THE NET ZERO TEESSIDE ORDER 2024 (S.I. 2024 NO. 174) (THE 'ORDER')

APPLICANTS' RESPONSE TO SECRETARY OF STATE COMMENTS IN RESPECT OF A NON-MATERIAL CHANGE TO SCHEDULE 1 'AUTHORISED DEVELOPMENT' AND SCHEDULE 2 REQUIREMENT 3(4) 'WORK NO. 3 DETAILS' OF THE NET ZERO TEESSIDE ORDER

LAND AT AND IN THE VICINITY OF THE FORMER REDCAR STEEL WORKS SITE (TEESWORKS SITE), REDCAR AND IN STOCKTON-ON-TEES

TITLE
WORKS PLAN. KEY PLAN
DOCUMENT REF. 4.4
WORK NUMBER 9 - TEMPORARY
CONSTRUCTION AND LAYDOWN AREAS

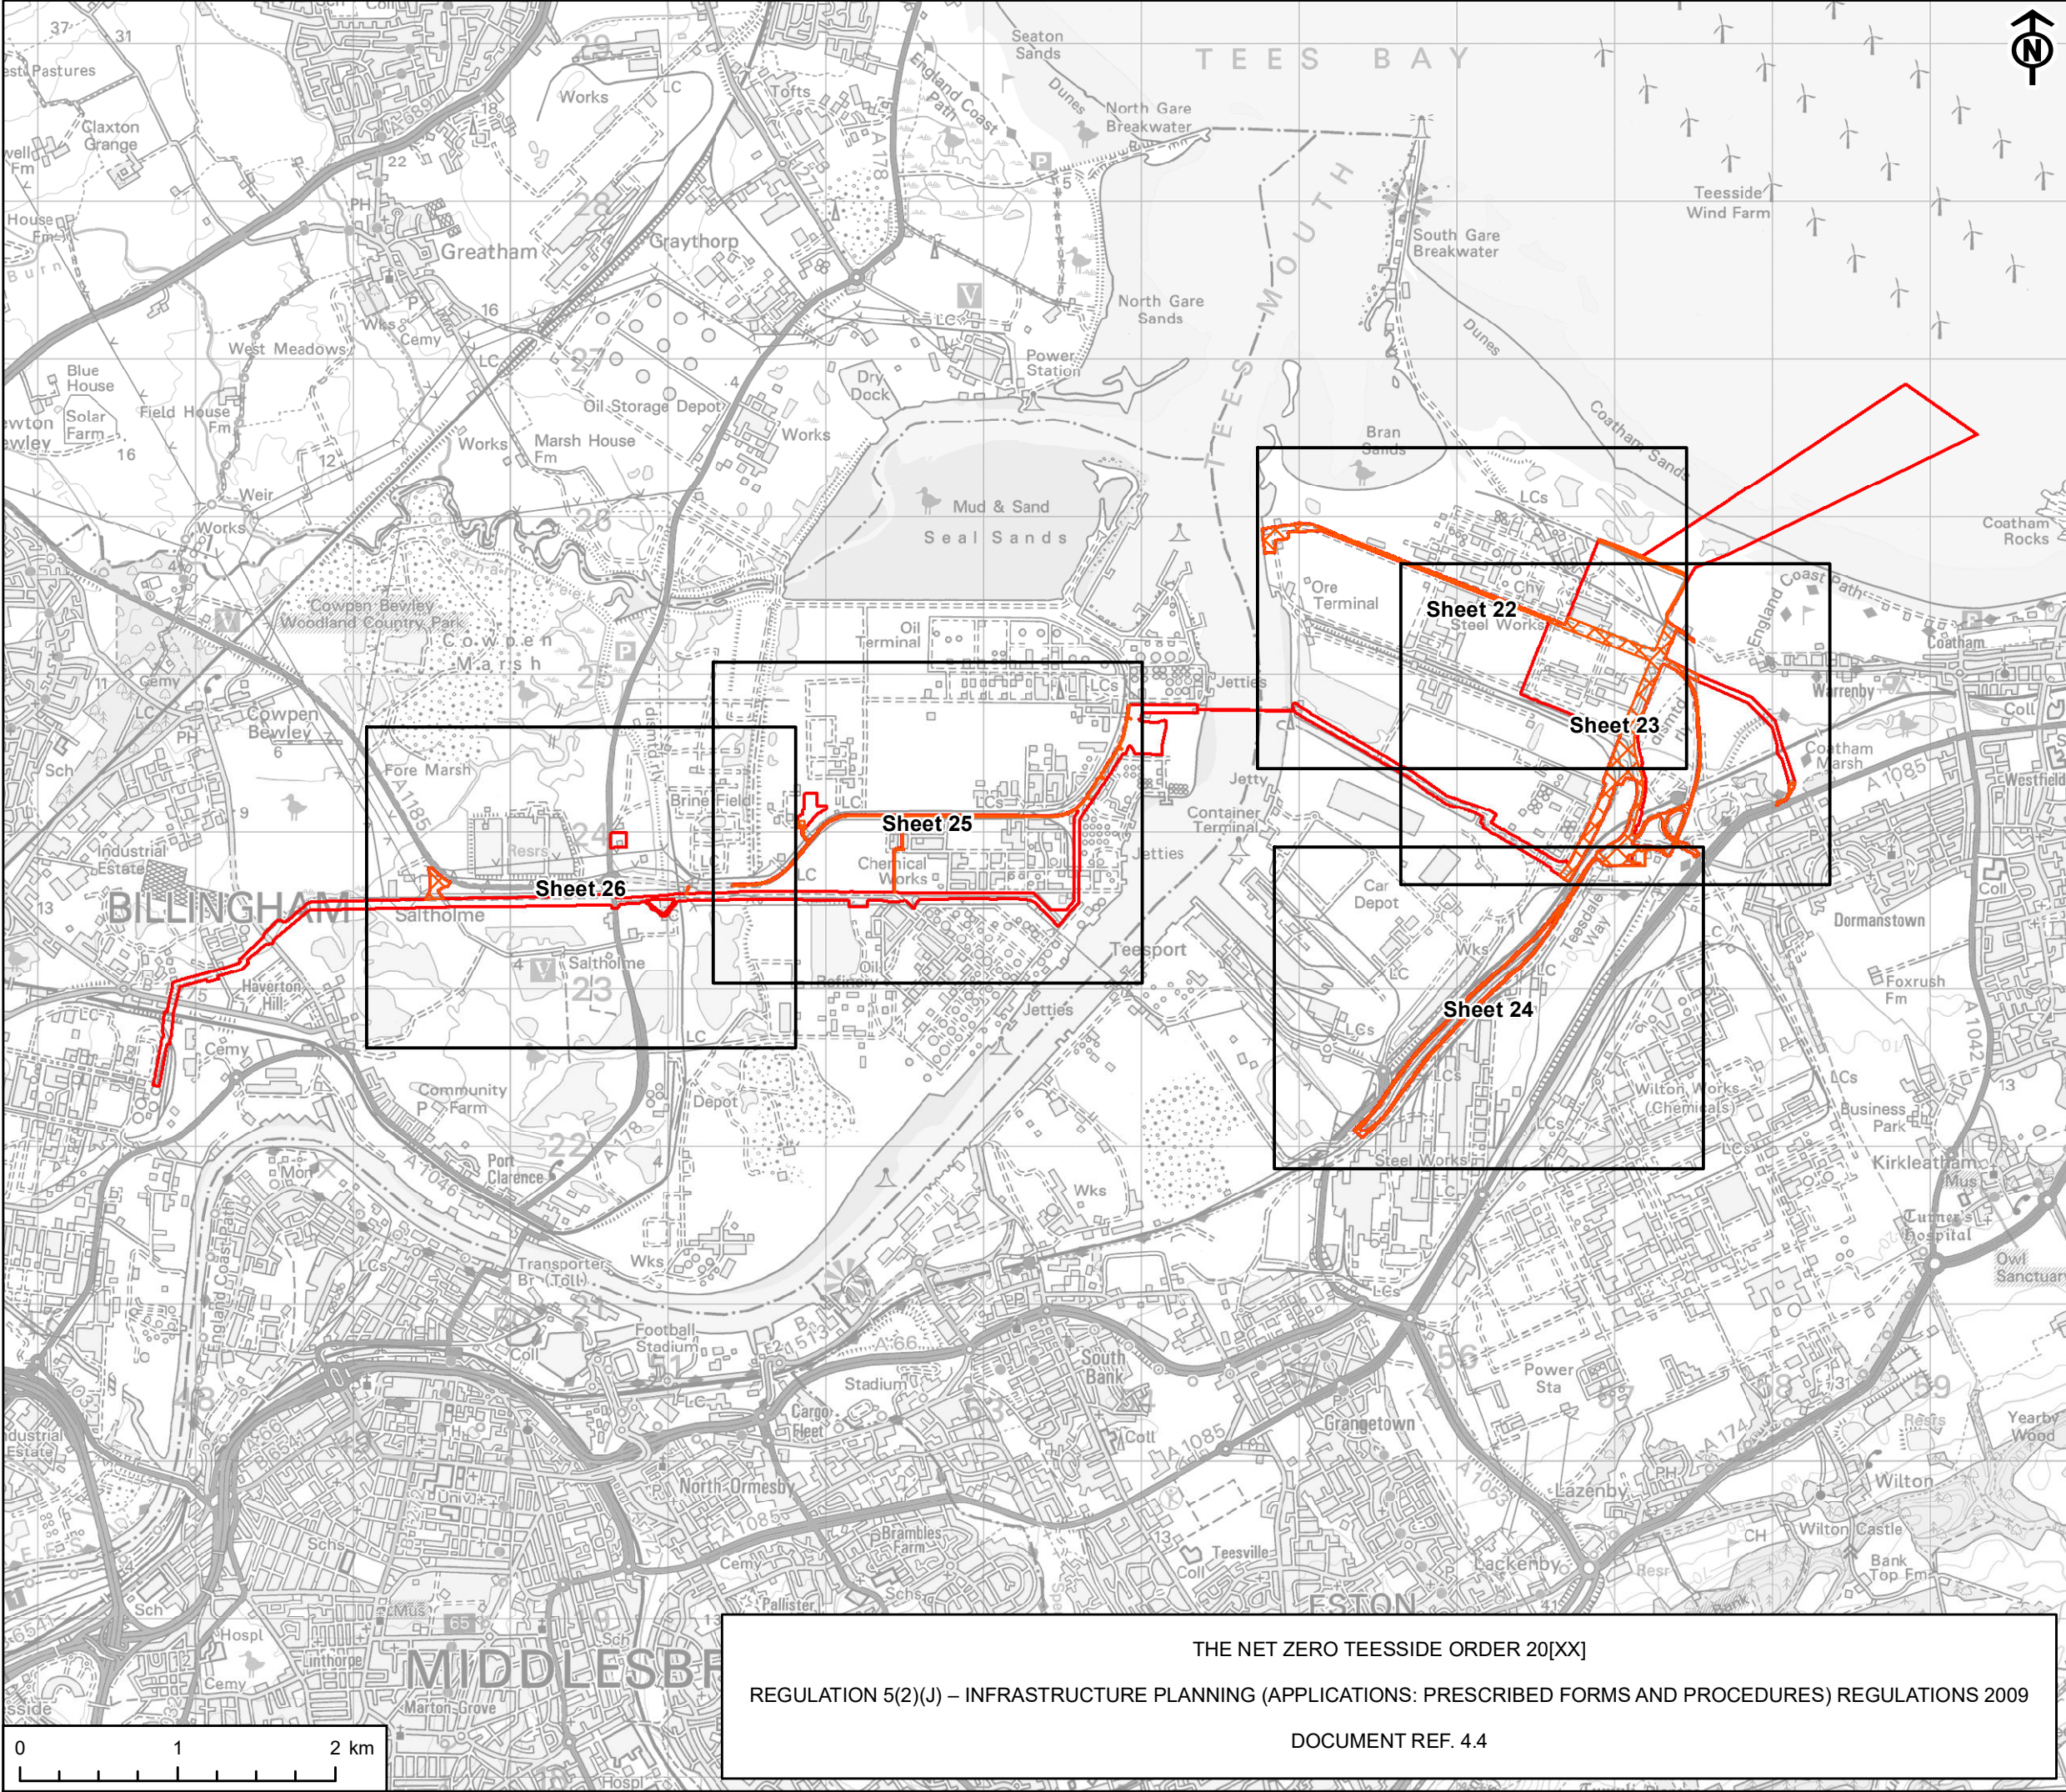
5. *“The Secretary of State notes that the period laydown areas are required for [Table 3-1] has a construction start date of Q4 2022. The Applicants are required to provide an update to reflect the current anticipated construction programme.*

In the Change Application, Table 3.1 has been reproduced from the Original NZT DCO ES with the only change being the addition of Work No. 9G (and other lines in the Table were not altered). All The dates for all lines in Table 3.1 should be read as “2025 to 2028”, based on a revised construction start date of 2025.
